Our Ref: BN/88/19/HH

**Town & Country Planning Act 1990 (as amended)
Town & Country Planning (Development Management Procedure) (England) Order 2015
Application for Planning Permission for Works or Extension to a Dwelling**

Development Single storey rear extension and first floor side extension including demolition of existing single storey rear extension.

Location 37 Gospond Road Barnham

BLOCK PLAN 1:500@A4

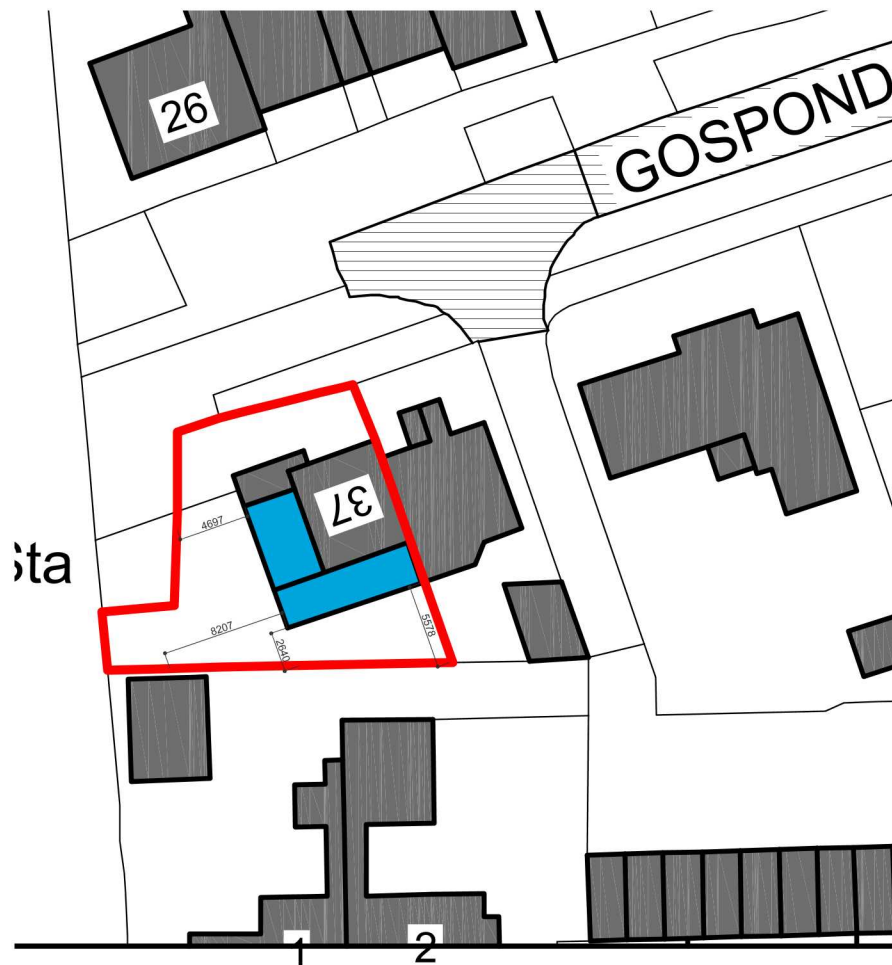
You are required to include dimensions on the block plan from the proposed extension to all site boundaries.
